# KITTITAS COUNTY

## DEPARTMENT OF PUBLIC WORKS

TO: All Staff  
FROM: Public Works Plan Review Team  
DATE: February 8, 2022  
SUBJECT: BL-22-00002 Haberman

The Public Works Department has reviewed the Request for Boundary Line Adjustment Application.

PART OF THE SOUTHWEST QUARTER OF SECTION 28,
TOWNSHIP 18 NORTH, RANGE 19 EAST, W.M.

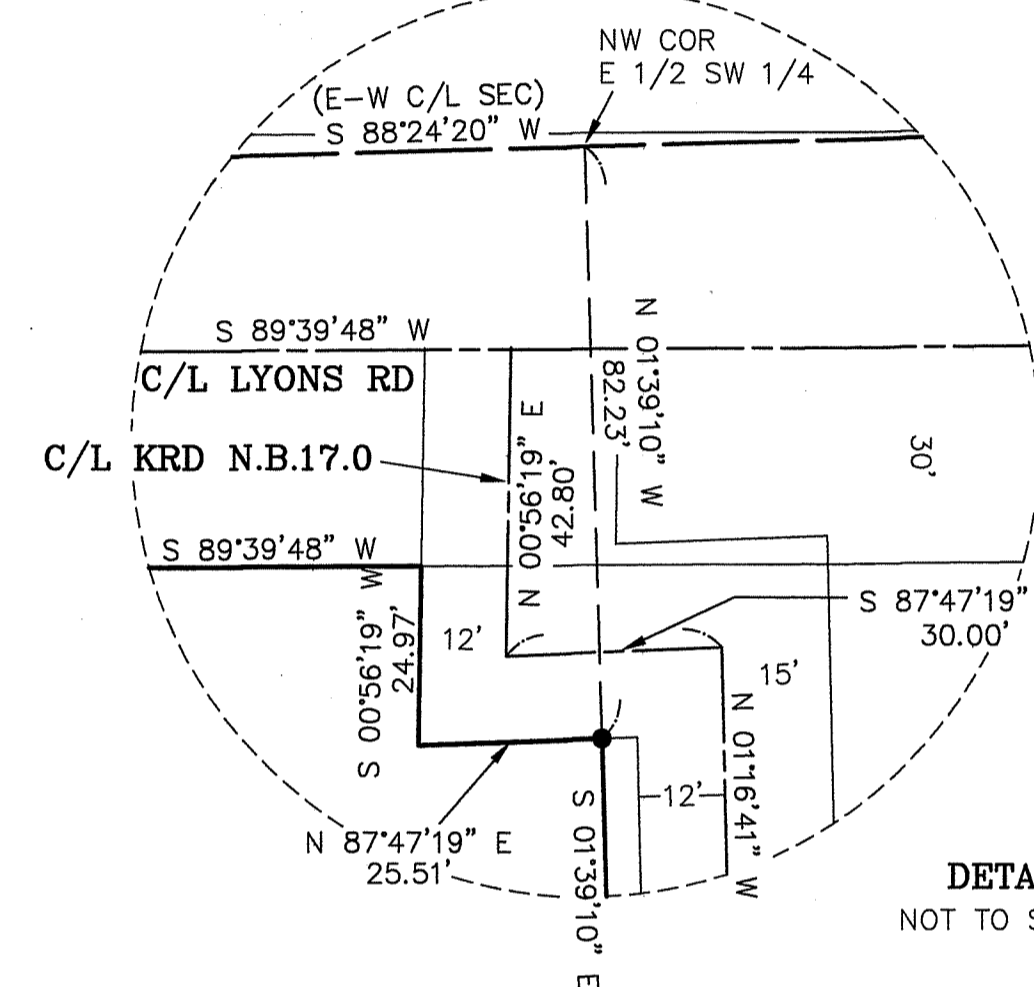
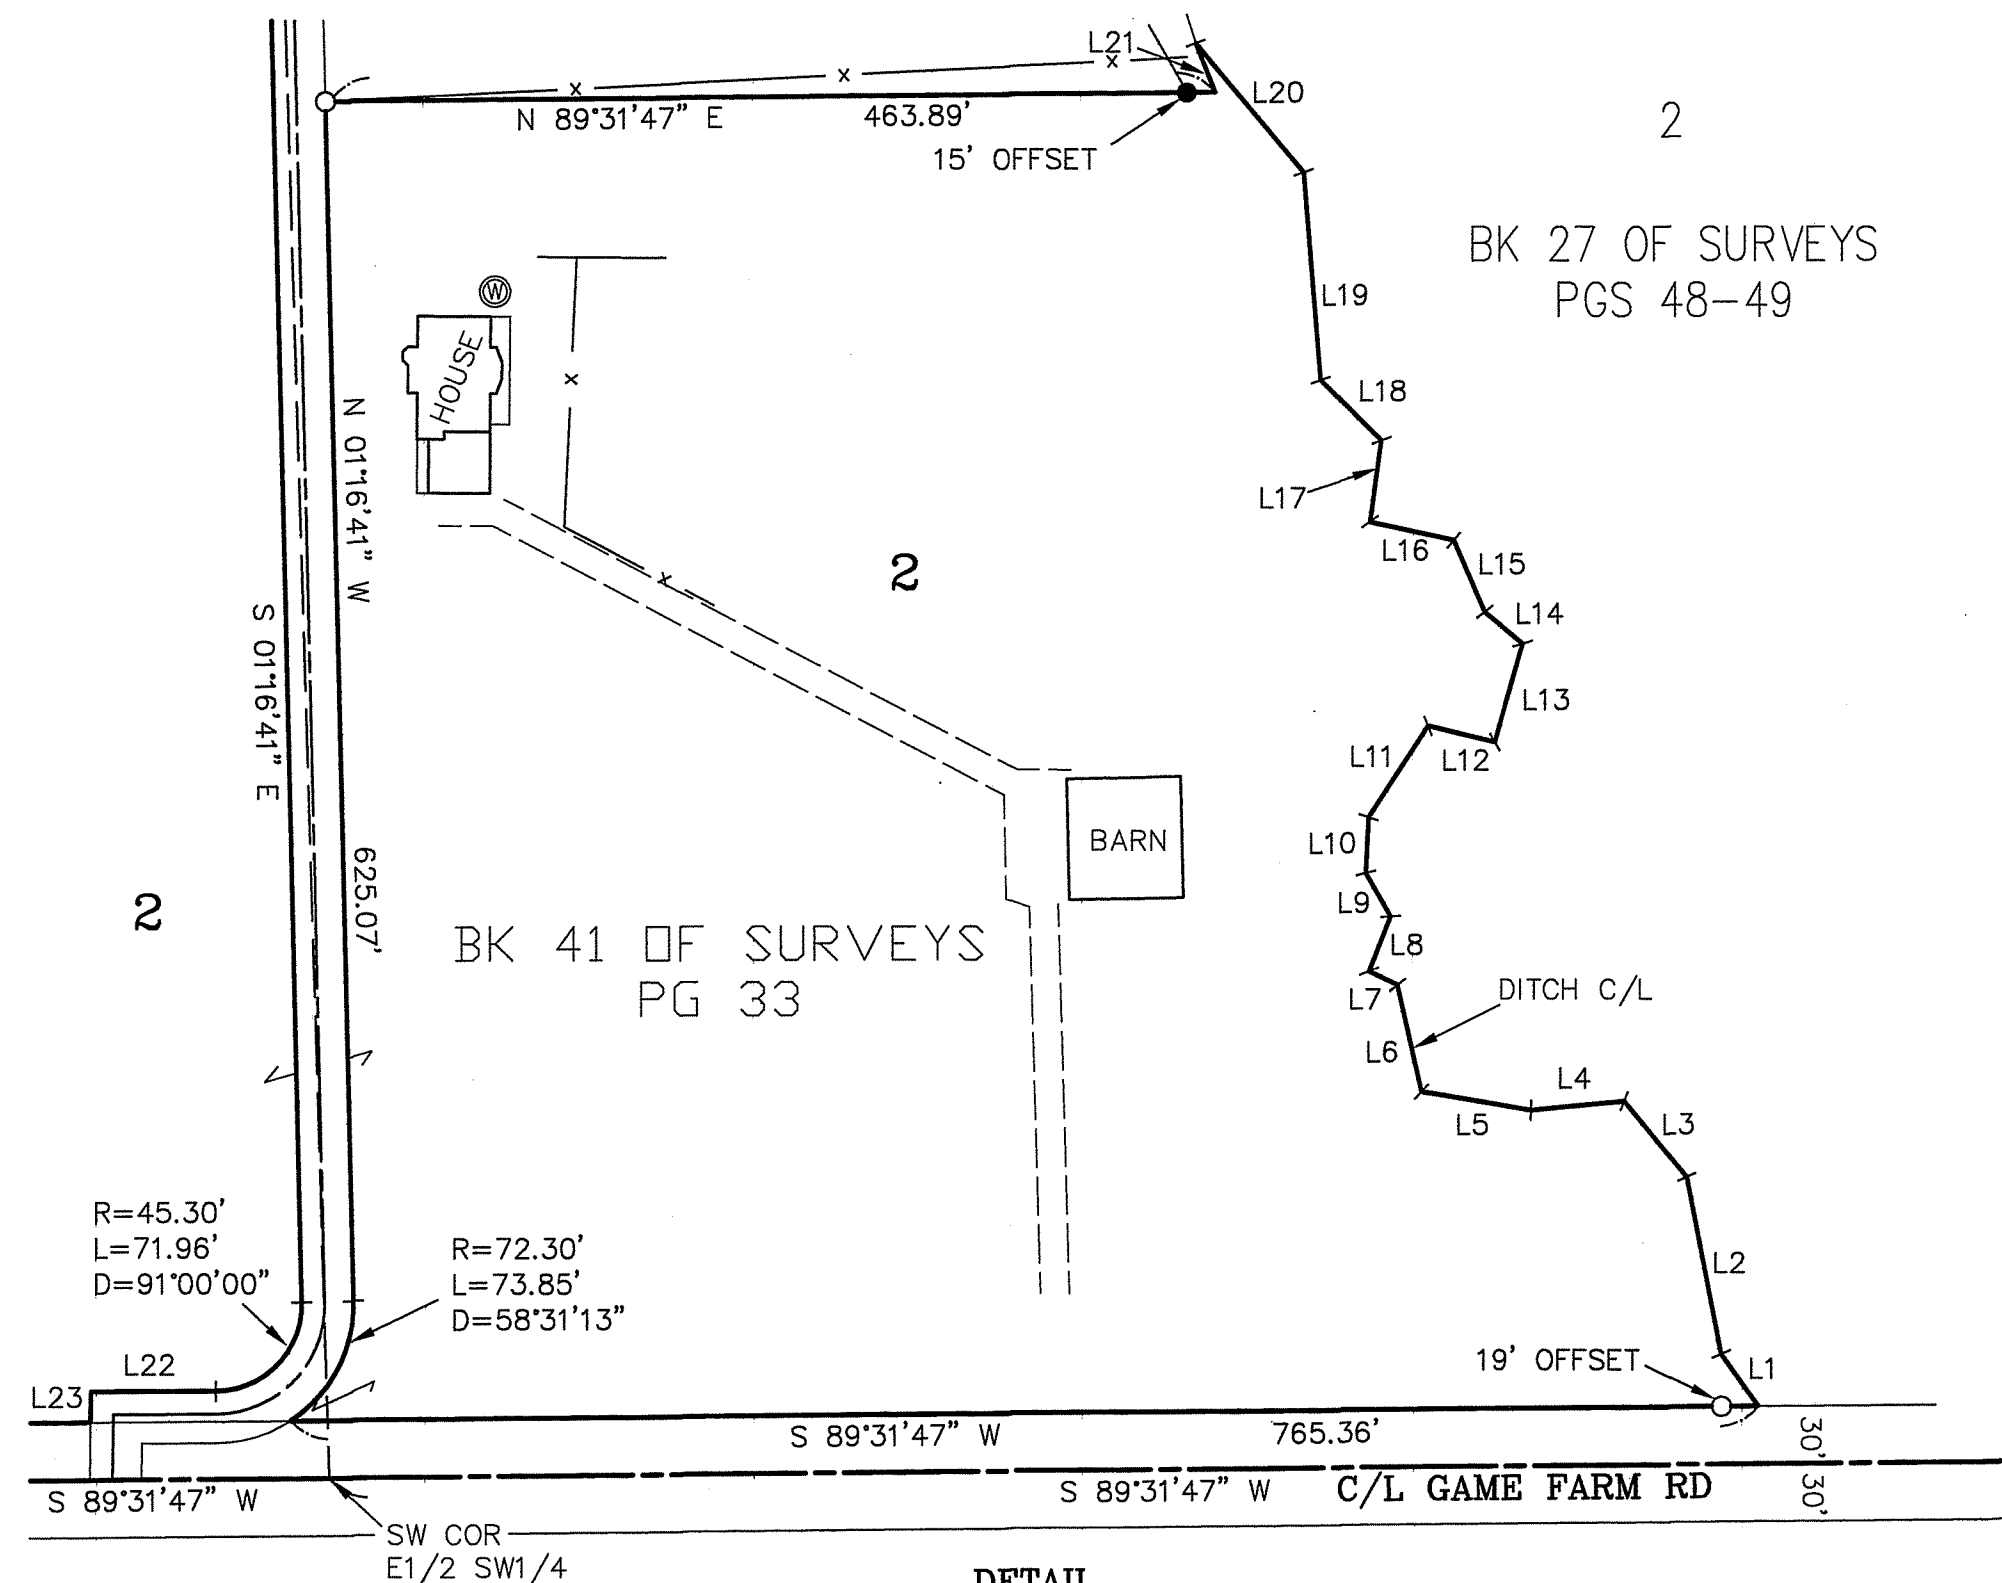
- h. A portion of Parcel 17648 is located in the FEMA identified 100-Year Floodplain. If possible, any future development should remain outside of the floodplain in order to reduce risk and avoid mandatory flood insurance purchase requirements. All activities within the floodplain must be permitted through the floodplain development permit process and follow the regulations within Kittitas County Code 14.08.

Site Plan

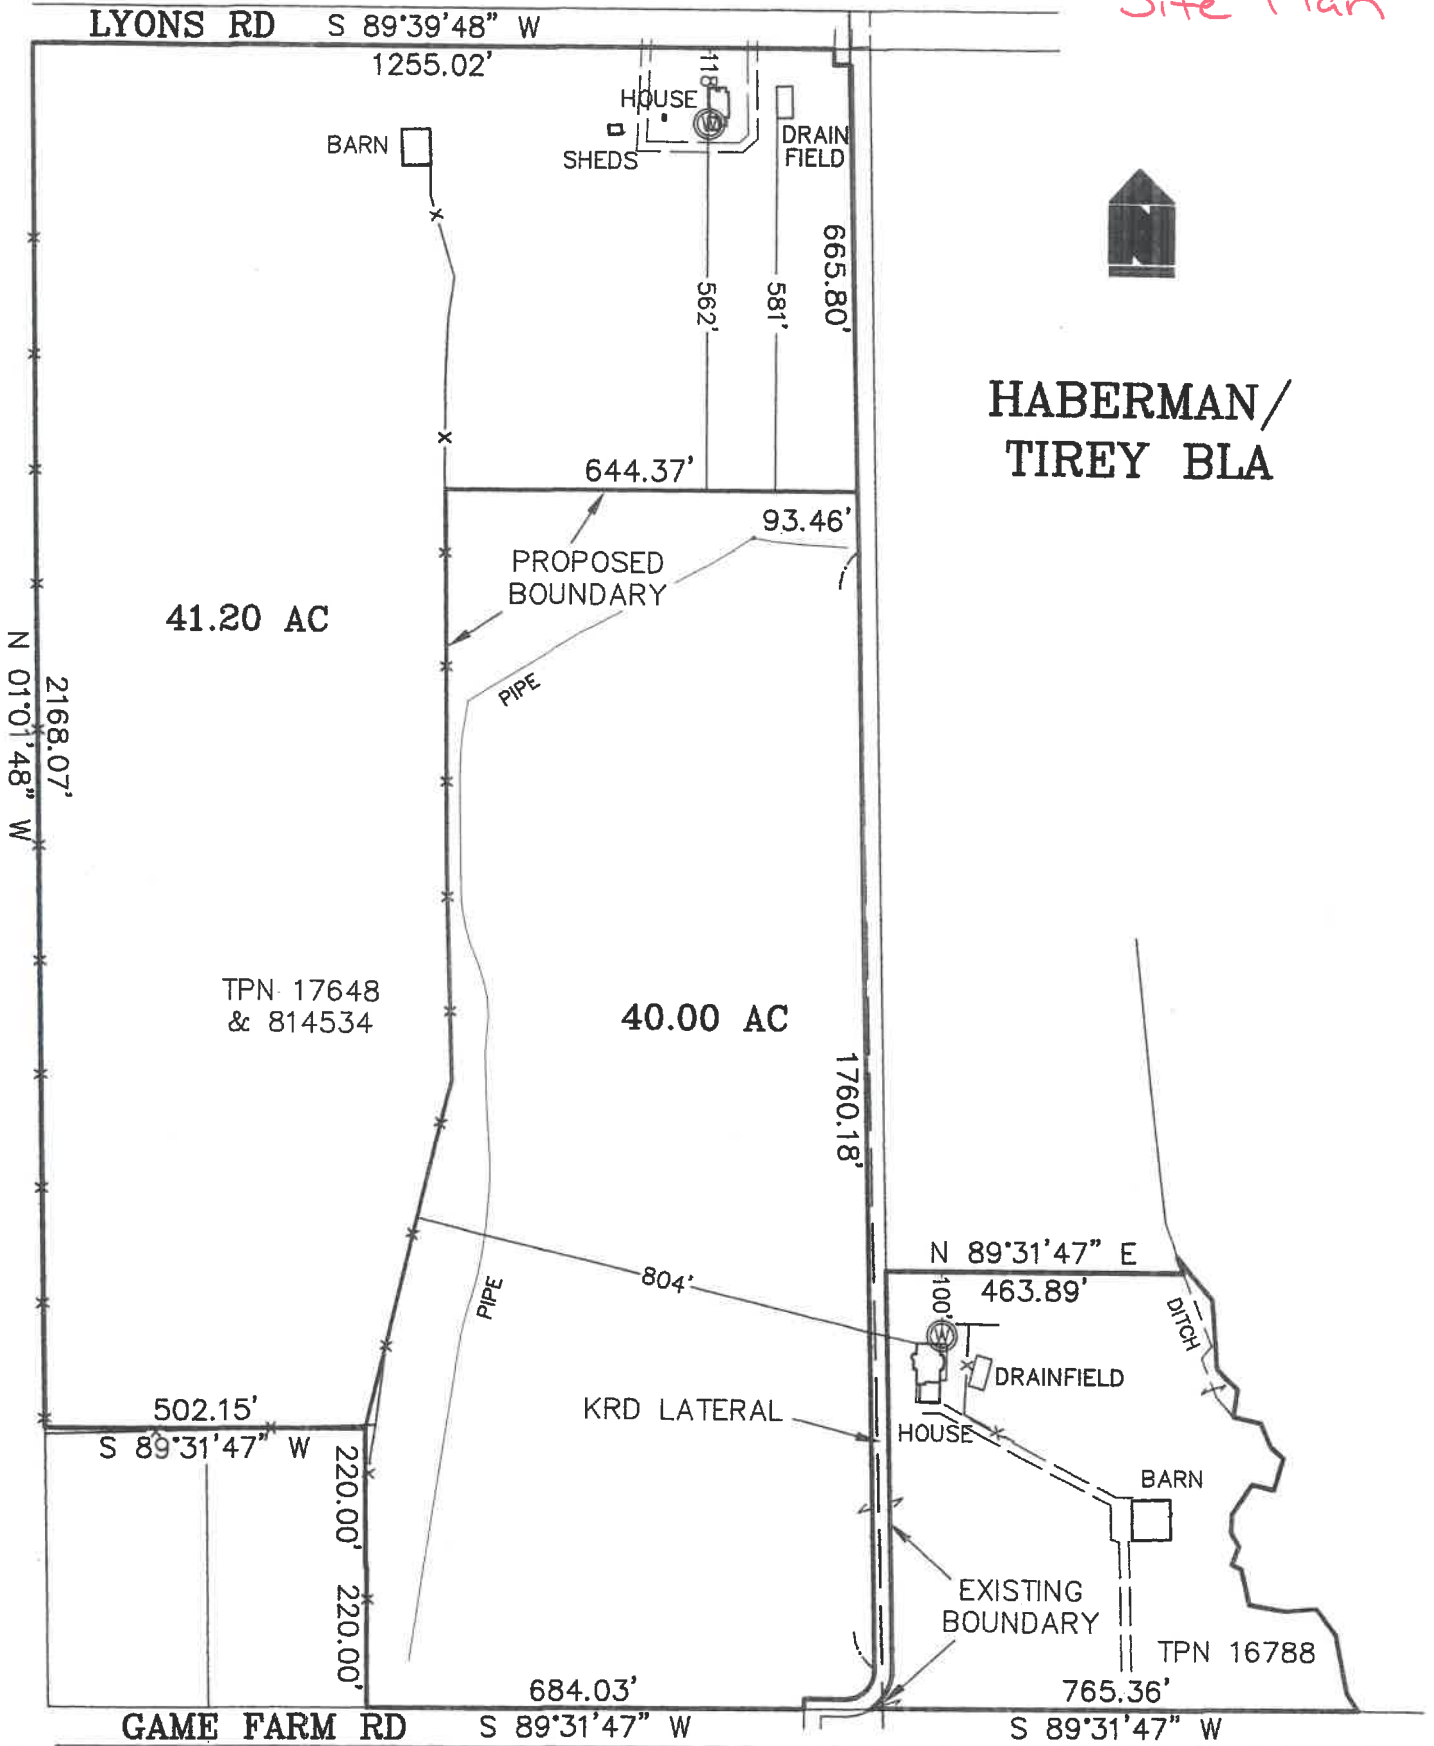
- f. In addition to the above-mentioned conditions, all applicable Kittitas County Road Standards apply to this proposal.
- g. The submitted site plans do not meet Kittitas County Code 16.10.020 which requires scaled drawings of both existing and proposed site plans as described in Kittitas County Code Title 15A.03.030.
